Our Ref: DOC20/569556

Your Ref: SSD 7198

RE: Response to Further information – SSD 7198 Moonee Beach Residential Subdivision.

LOT LAYOUT

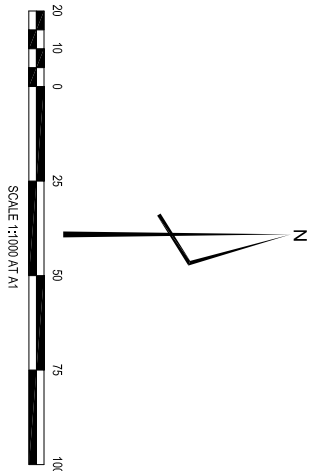
For biodiversity matters, the BCD is still of the view that an appropriate vegetated buffer is required for Moonee Creek to protect the integrity of the waterway and provide on-site biodiversity values for the locality.

We note that the latest JW Planning response has not adequately addressed the buffer to Moonee Creek. The Modification Report states that detailed investigations of the site determined that a buffer with an average width of 72m (excluding APZs and any infrastructure) should apply to Moonee Creek. The development plans should be amended to ensure this buffer can be appropriately applied, whilst recognising that the buffer will not be able to be fully achieved in the south-eastern corner where the required connector road must be constructed.

1. The development plans should be amended to ensure that a buffer with an average width of 72m (excluding APZs and any infrastructure) can be incorporated, whilst recognising that the buffer will not be able to be fully achieved in the south-eastern corner where the required connector road must be constructed.
2. Further clarification and a summary of changes is required regarding the updated Biodiversity Offset Strategy.
3. If the applicant is seeking to stage the development, a staging plan with corresponding biodiversity credits to be retired prior to each stage must be provided for review.
4. Further information is required on how the proposed development satisfies the requirements of Clause 8 of SEPP 71, or otherwise how any impacts of or on coastal processes and coastal hazards will be managed and/or mitigated.
